# **HyNet Carbon Dioxide Pipeline**

Written Representation on behalf of Peel NRE

Planning Inspectorate Reference: EN070007

17 April 2023

DRAWING TITLE  
**Ince - Above Ground Installation (AGI) Drainage Layout**

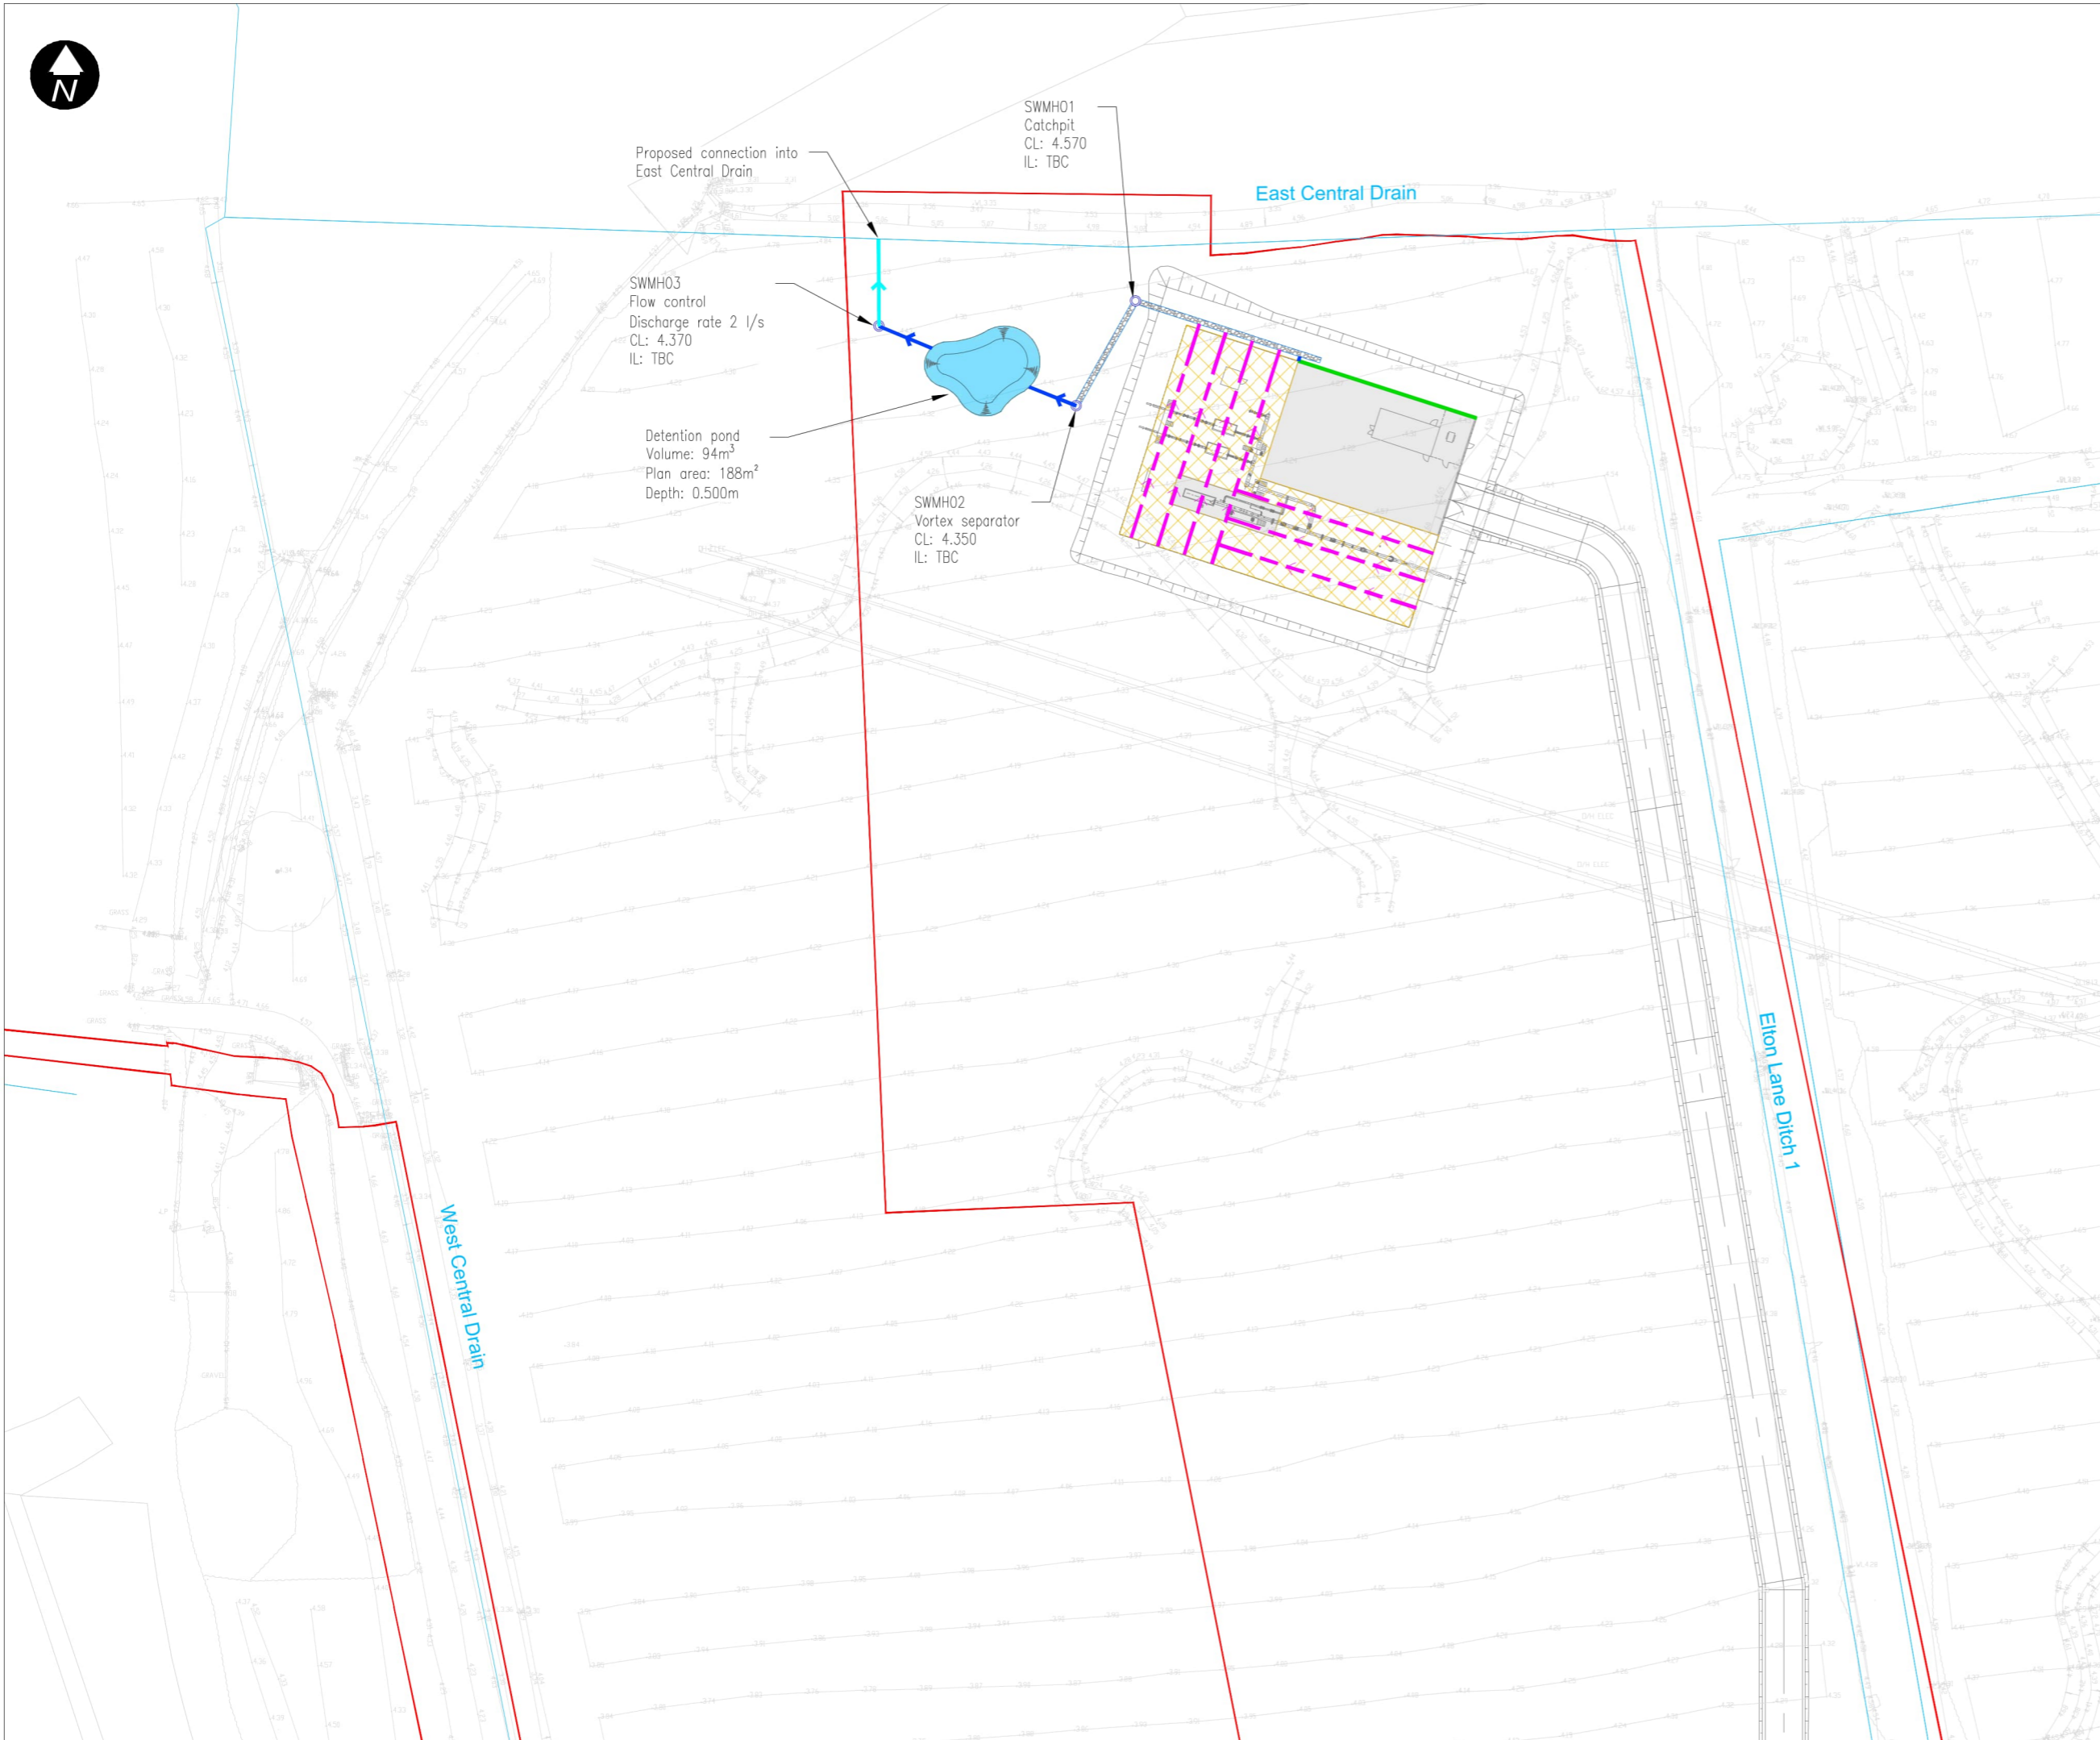
- 3.15 Additionally, the layout of the Ince AGI (as shown on plan ref. EN070007-D.2.10-LAY-Sheet 1) orientates the infrastructure adjacent to an existing drain which travels in an east/west direction to the north of the Ince AGI (East Central Drain) (an Environment Agency "main drain"). The location of the Ince AGI and associated surface water drainage infrastructure needs to be a sufficient offsetting distance from the main drain and also incorporate sufficient space for future planned infrastructure within this area.

- 3.19 Additionally, the layout of the Ince AGI (as shown on plan ref. EN070007-D.2.10-LAY-Sheet 1) orientates the infrastructure adjacent to an existing drain which travels in an east/west direction to the north of the Ince AGI (East Central Drain). This drain is known for the presence of Water Voles. Additional Water Vole survey work is understood to be completed, with this to be submitted as supplementary information during the determination of the DCO. This information is requested by Peel NRE to fully understands the impacts of the Application.

Figure 6.1 – Extract of the Ince Park Plastics Masterplan - Drawing Number: 20039-FRA-XX-00-DR-A-90-0005 P2 approved under application no. 21/04076/FUL and works no.3, EN070007-D.2.4-WP-Sheet 1 [AS-012].

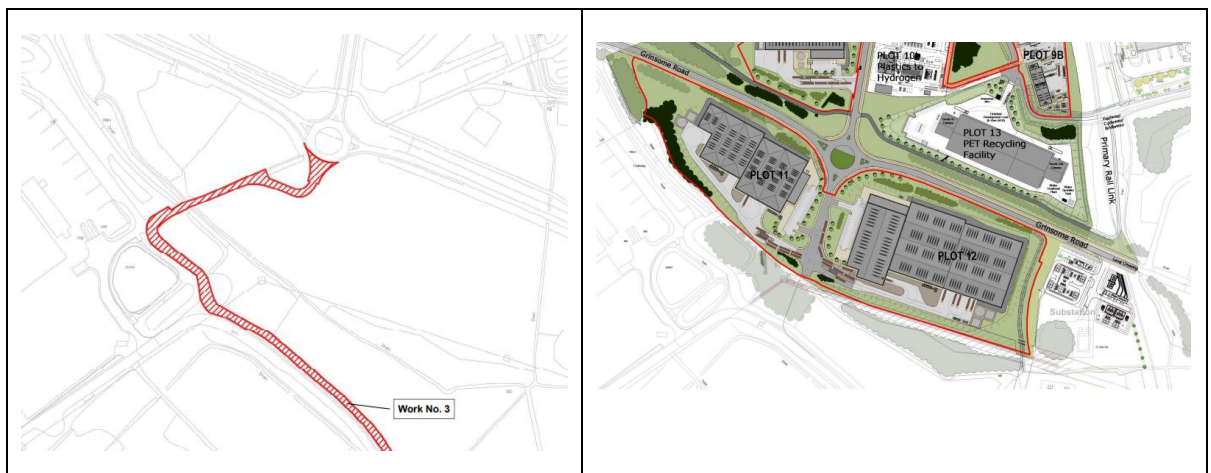
- 3.21 The proposed access road from Grinsome Road roundabout to the Ince AGI and pipeline corridor (as shown on Works Plan ref. EN070007-D.2.4-WP-Sheet 1) conflicts with the delivery of the approved Protos Plastics Park (CWACC Planning application ref. 21/04076/FUL), and the delivery of the railway line consented as part of the overarching planning permission for Protos (ref. 14/02277/S73), which would constrain the delivery of the developments. Therefore, at this stage, Peel NRE **objects** to the proposed access (as shown on Works Plan ref. EN070007-D.2.4-WP-Sheet 1).

- 3.22 A plan of the approved Plastics Park masterplan (ref. 20039-FRA-XX-00-DR-A-90-0005 P2) is provided with an overlay of the proposed access route to the Ince AGI and pipeline (shown on plan ref. EN070007-D.2.4-WP-Sheet 1). This is provided at **Appendix 16**. This overlay plan clearly shows the conflict of the Applicant's proposed access with the planned development of the Plastics Park at Protos. A plan of the approved railway line is provided at **Appendix 17** (plan ref. 0775/SK/05).

DRAWING NUMBER
 EN070007-APP-ES-6.3-Sheet 2

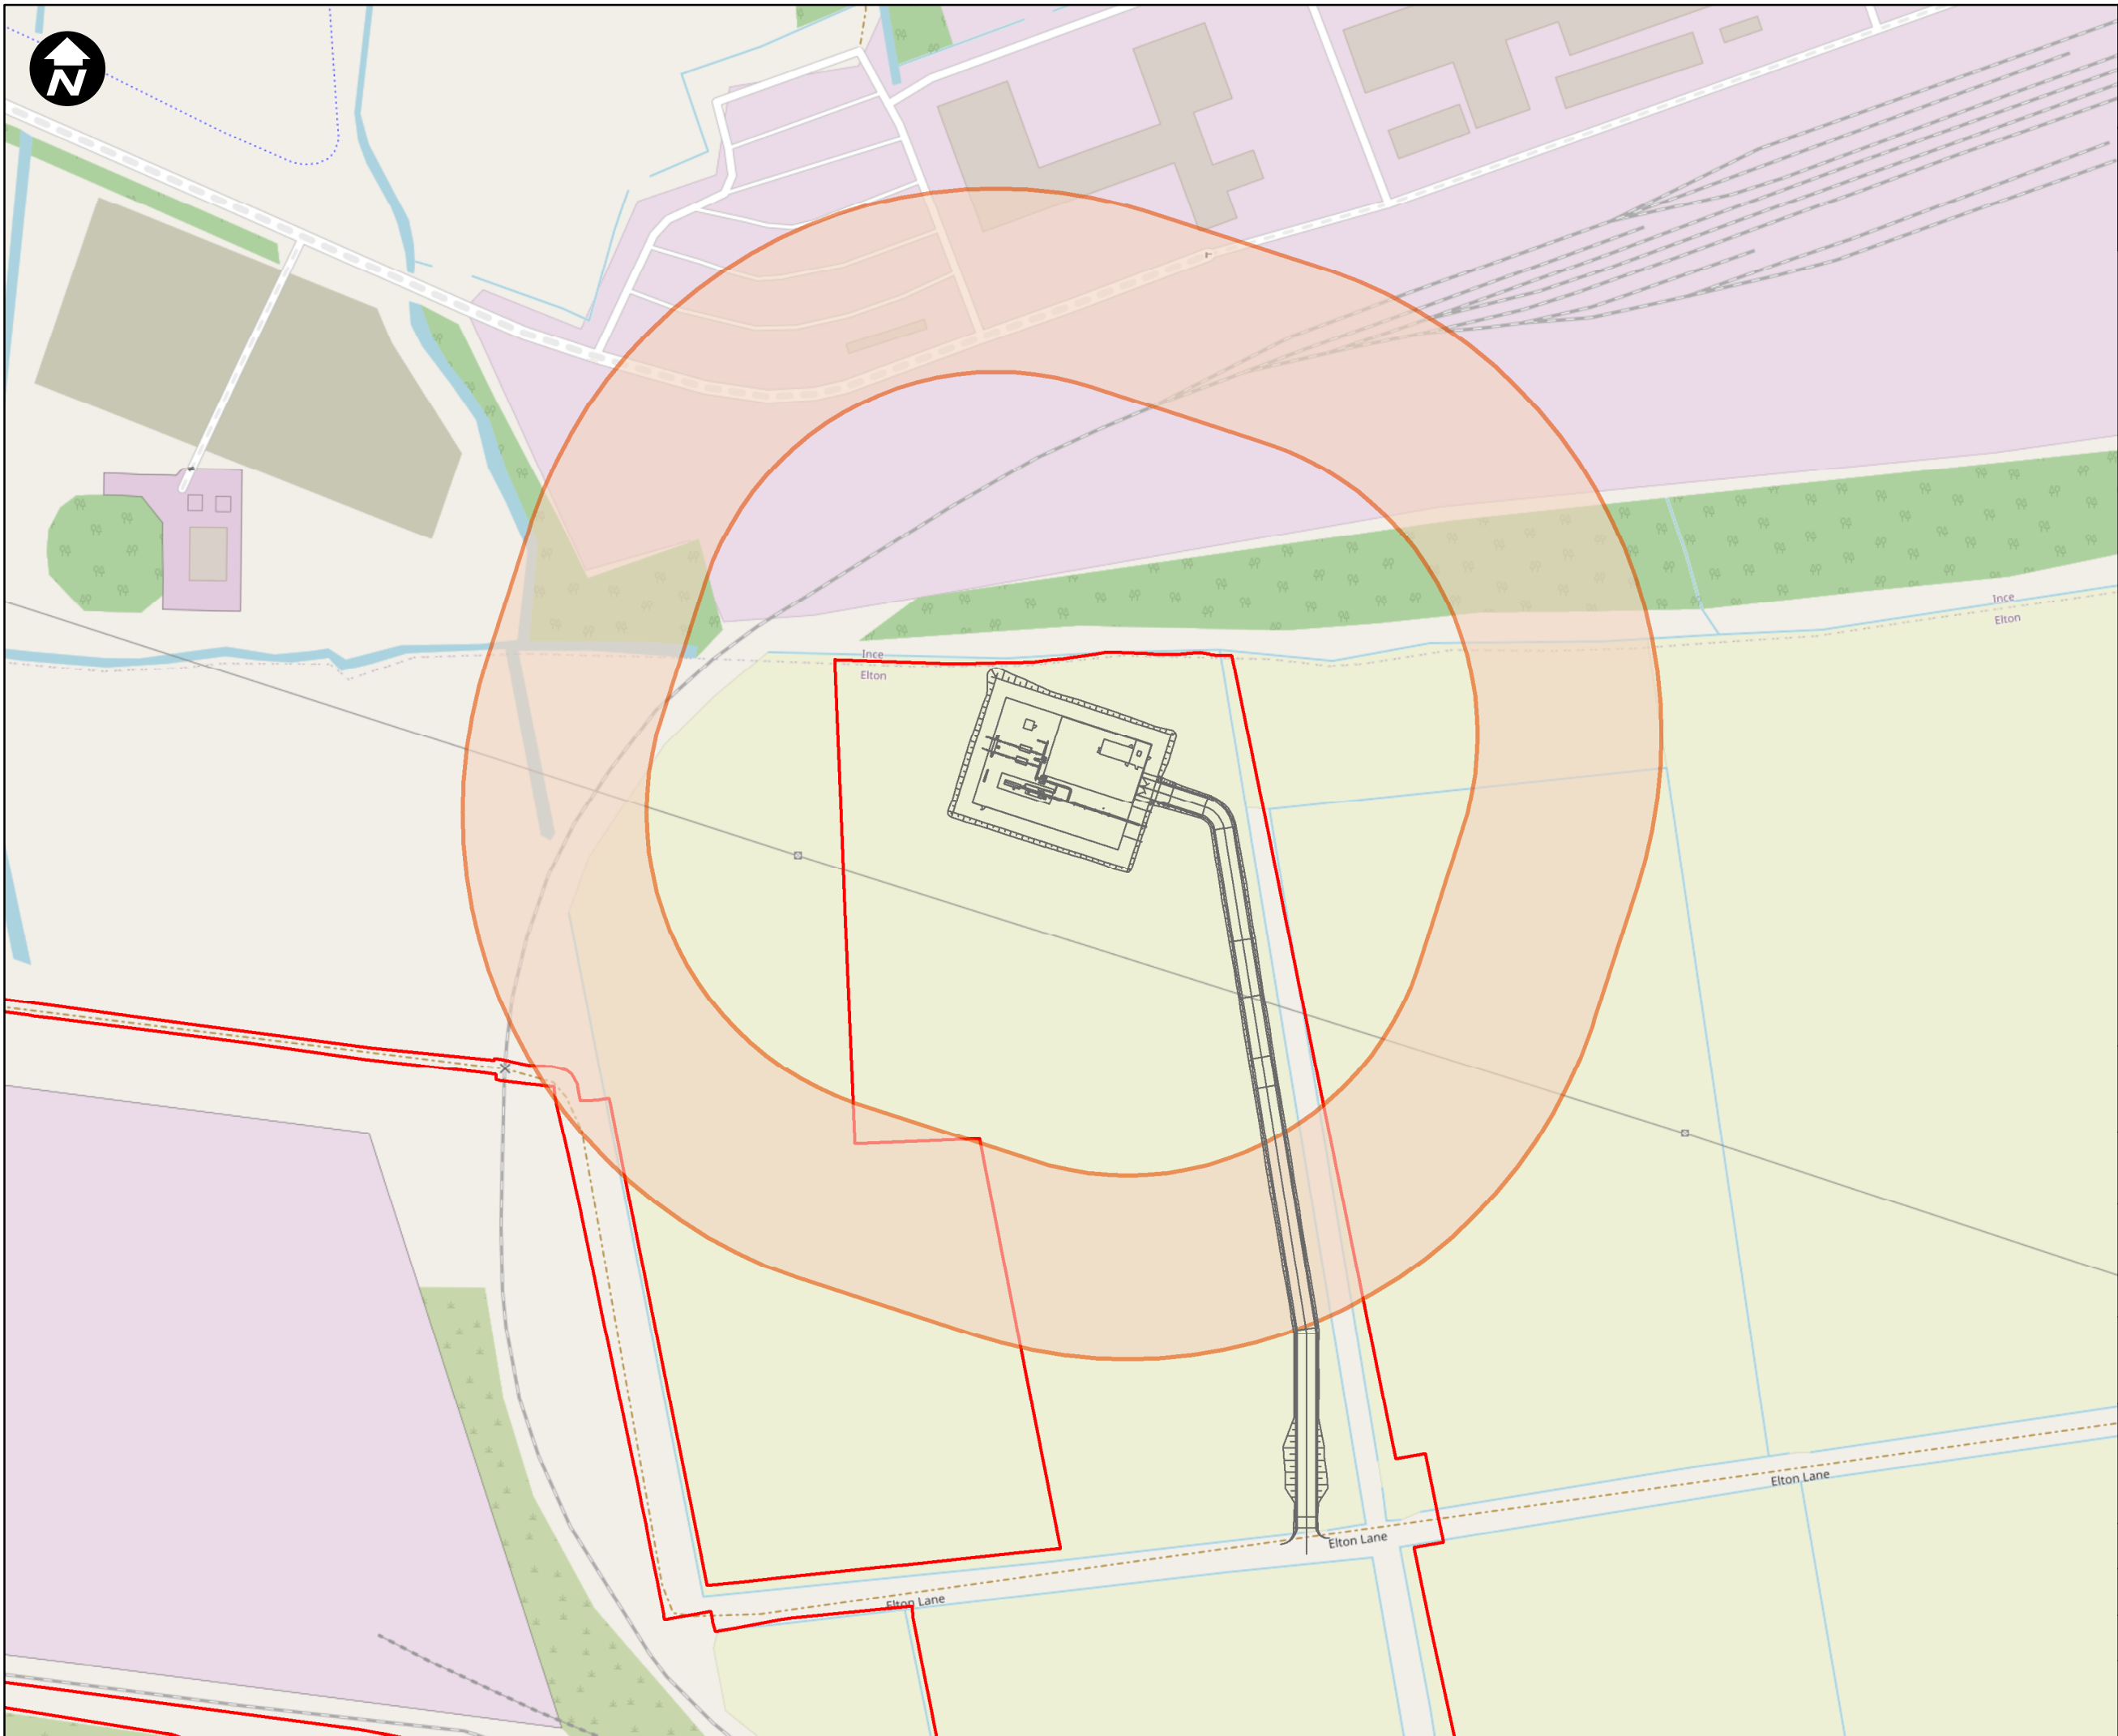
- 3.27 The Applicant has identified the potential for odour emissions at the Ince AGI, with associated Odour Zone, which lies close to Protos (shown on Figure 6.3). Further consideration should be given to commercial and industrial uses nearby as part of the assessment. It is understood that such emissions can be mitigated through the adoption of an appropriate odour management regime.
- 3.28 Peel NRE **objects** on the basis that the odour management plan has not been provided as part of the information submitted as part of the DCO application outlining the anticipated management regime.
